State Significant Development Application Number SSD-10300.
Coffs Harbour Cultural and Civic Space.

I object to this proposal and desire and request that a public hearing be held.

GORDON ST ELEVATION

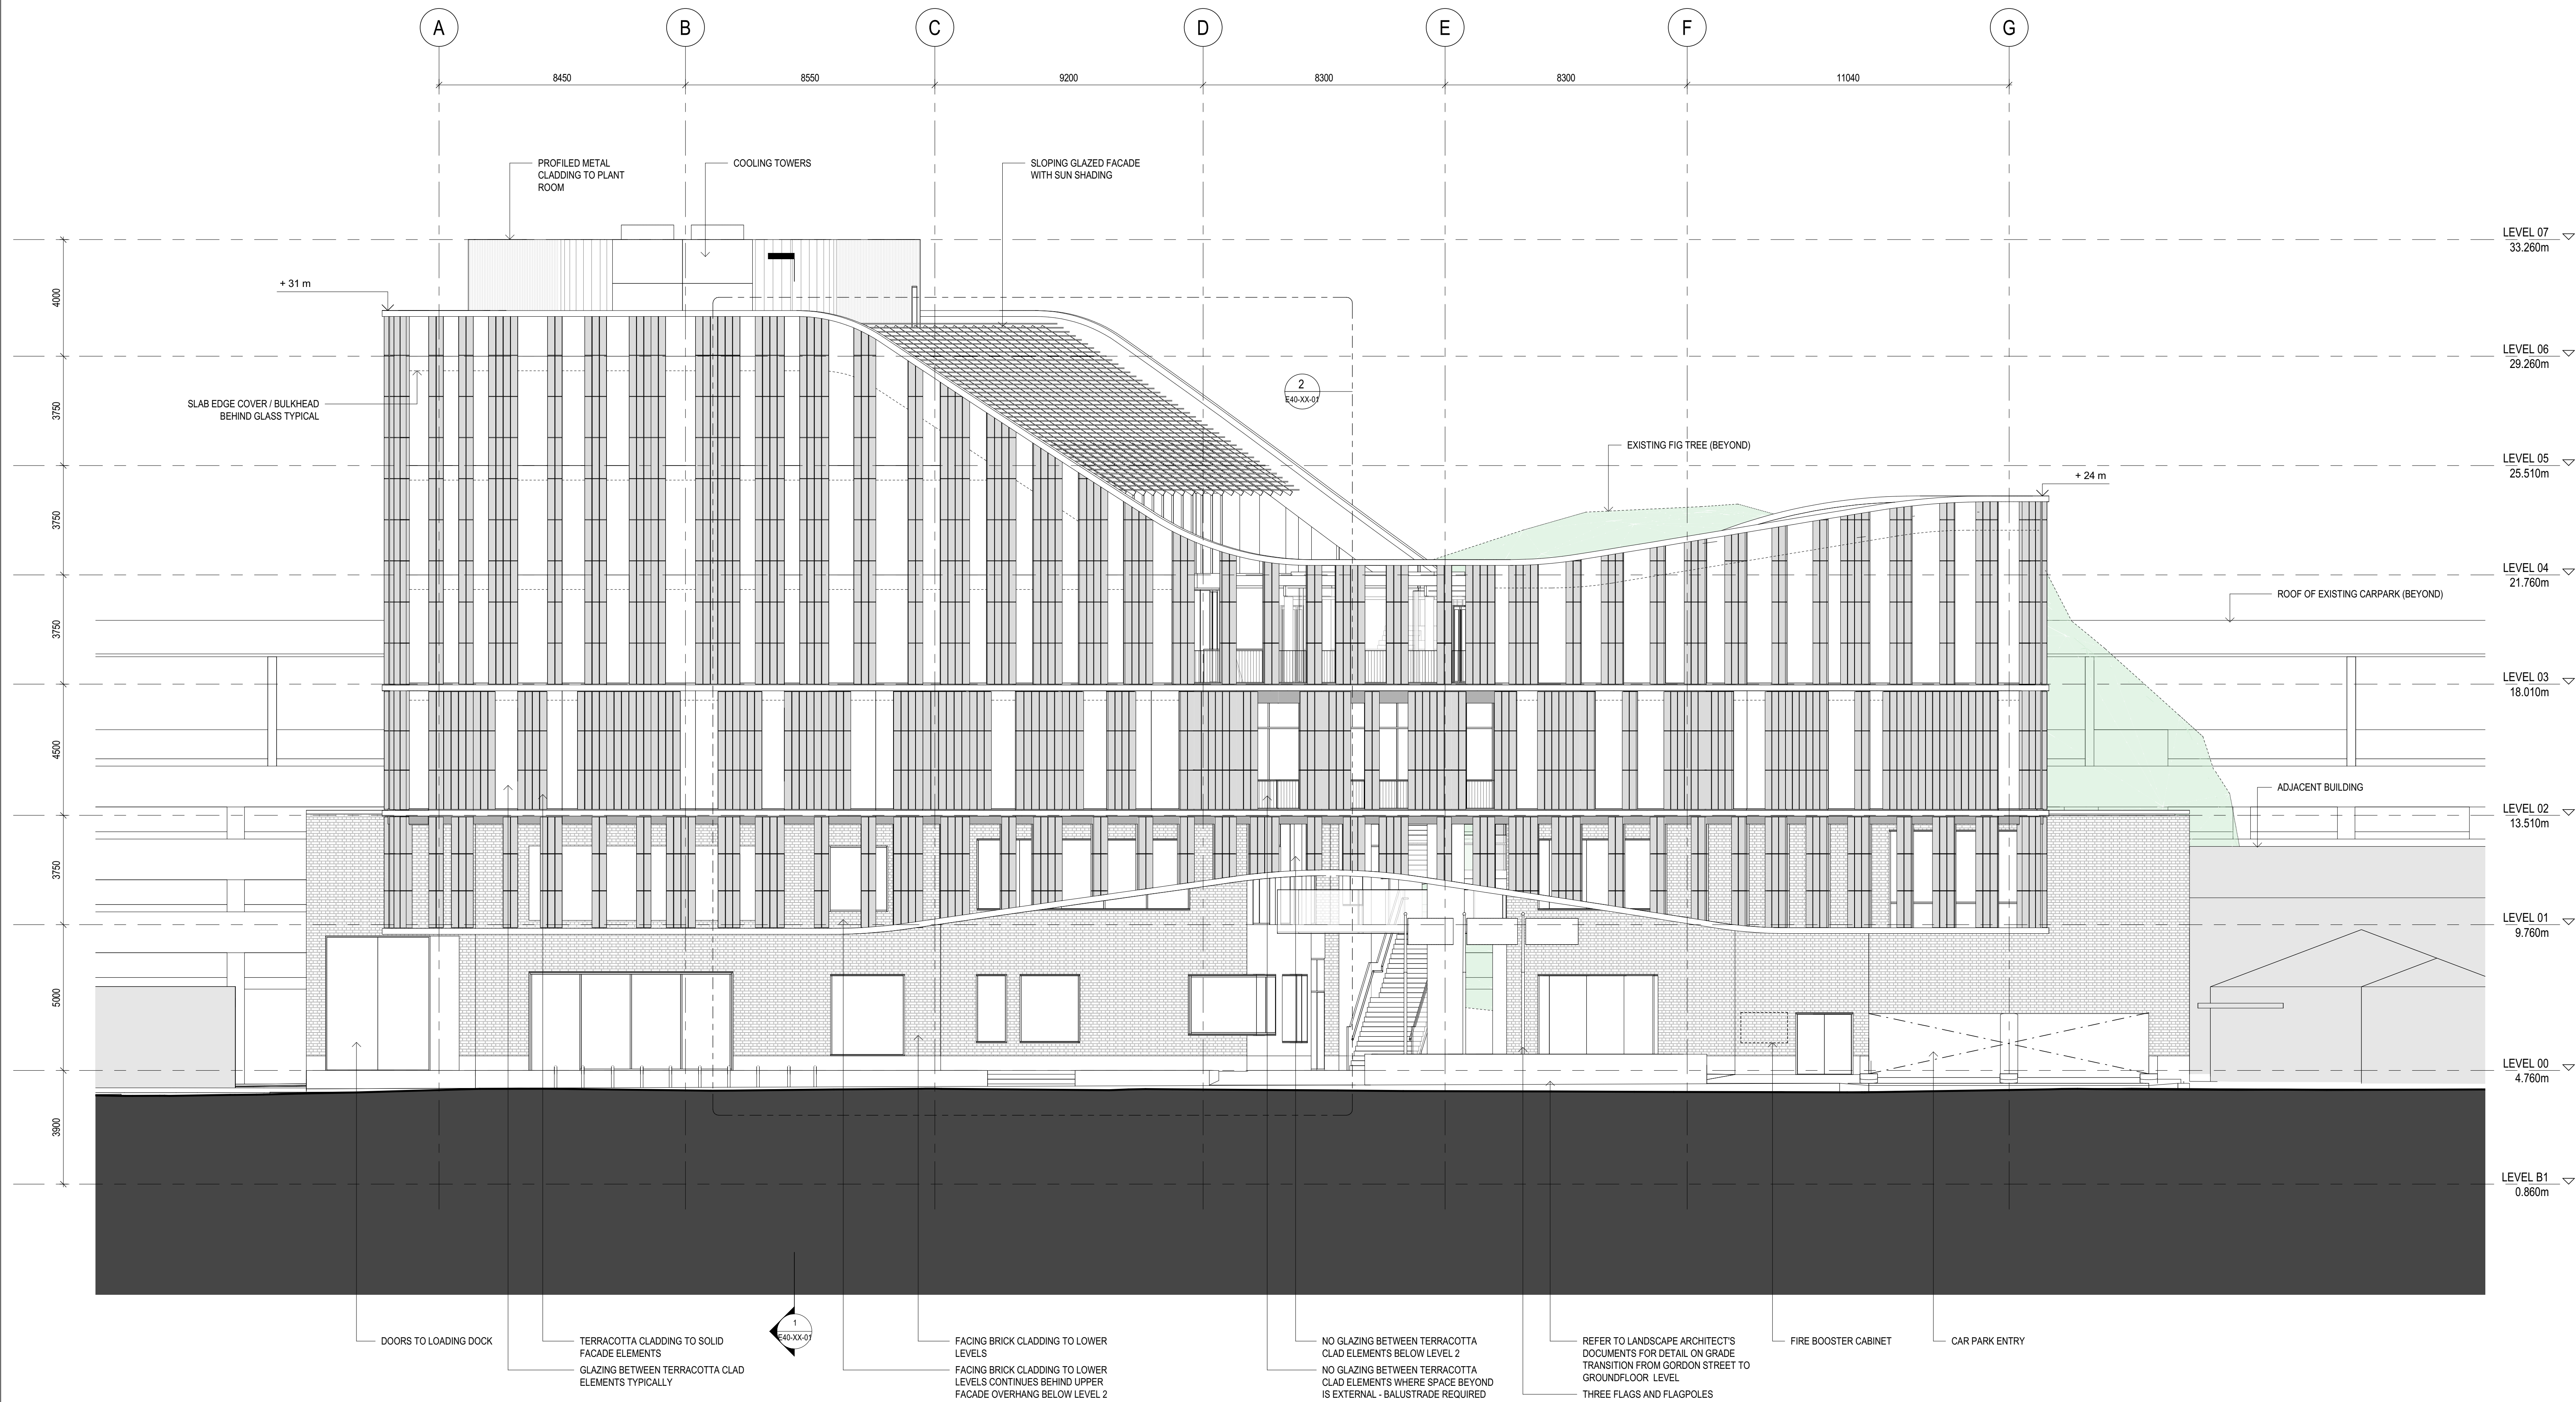
3. It conflicts with the streetscape in Gordon Street in that the proposed building is outside the context of this street having regard to the scale, existing street setbacks, design and general form of the adjoining buildings.
